Subject: RE: EP/39/22/PL 29 Tamarisk Way
Importance: High

Figure 1 - Previously Approved Northern Elevation

Figure 2 - Proposed Northern Elevation

Figure 2 - Proposed Northern Elevation

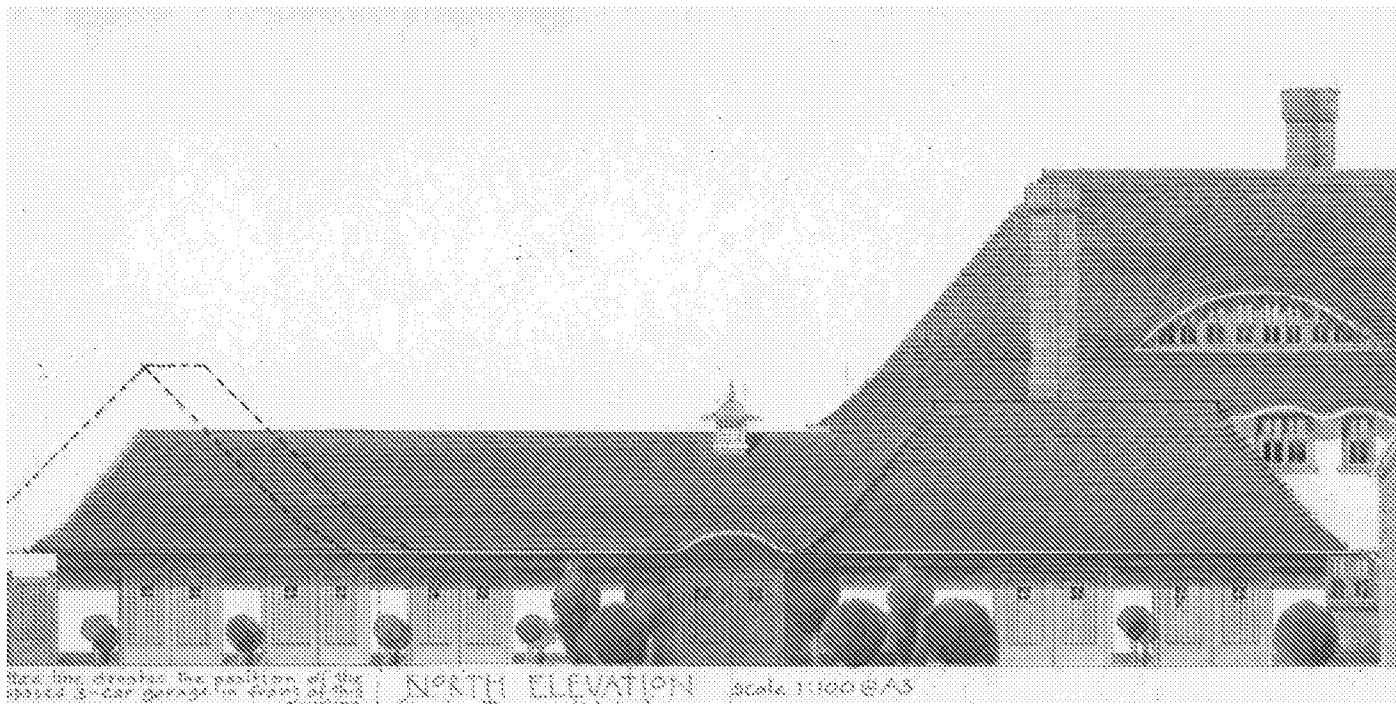
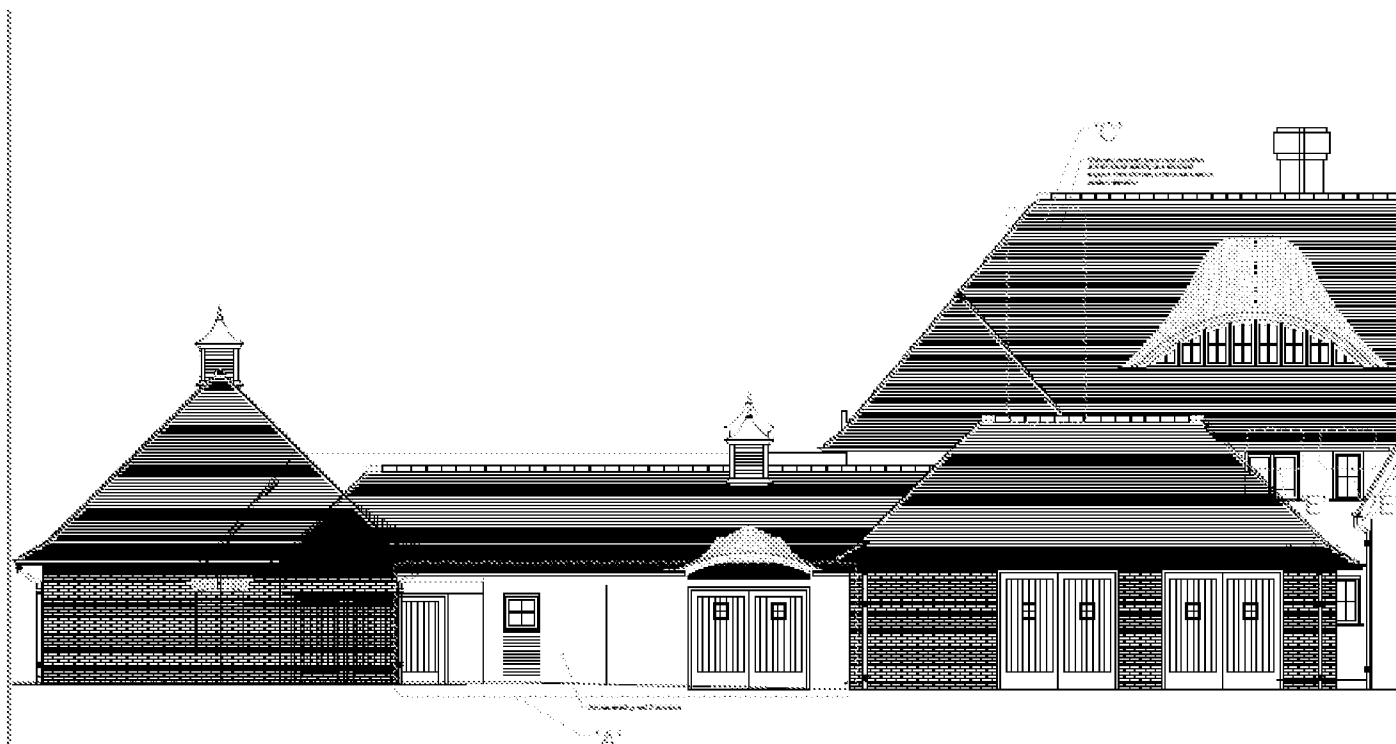
Apologies for the delayed response relating to the above application which was recently transferred over to me. Having now looked through the application documentation and recent correspondence with Obafemi and having had the chance to discuss the case with Juan, we feel that the loss of the eyebrow dormers would have a detrimental impact to the character of the building.

As a Locally Listed Building any alterations are expected to relate sensitively and respect the architectural interest as per Policy HER DM2 of the ALP. As stated above the eyebrow windows form part of the character and as such we seek to preserve these features of interest. I understand that there are difficulties relating to the rainwater gear however, technical matters of design are not a concern for planning, and we would request you seek an alternative method to install the guttering whilst maintaining the special architectural features of the building.

The aspects which we believe you to be referring to are those sections above the windows, identified as 'E' on the proposed plans. Please could you confirm? If so then, as you have acknowledged, we would not be able to provide these design features due to the proposed rain water guttering. This has been explored and unfortunately there is not another method available in providing the guttering without detriment to the visual impact of the building which is considered to be more significant than the loss of the design features to these windows. We would therefore suggest that there is not an alternative method to install the guttering.

The browed eaves were not structural and were part of the thatch roof which the original consent gained permission to remove. The browed eaves are not supported by timber substructure and we therefore cannot replicate such minor protrusions within the tiled roof.

Although the proposed plans seek to remove the browed eaves above the windows, the scheme seeks to retain the eyebrow dormers as previously approved at roof height and ground floor. The eyebrow dormers are considered to

be the special architectural features of the building which are capable of being delivered. Unfortunately it is not possible to deliver the browed eaves as part of the tiled roof. This was only possible with the thatch roof.
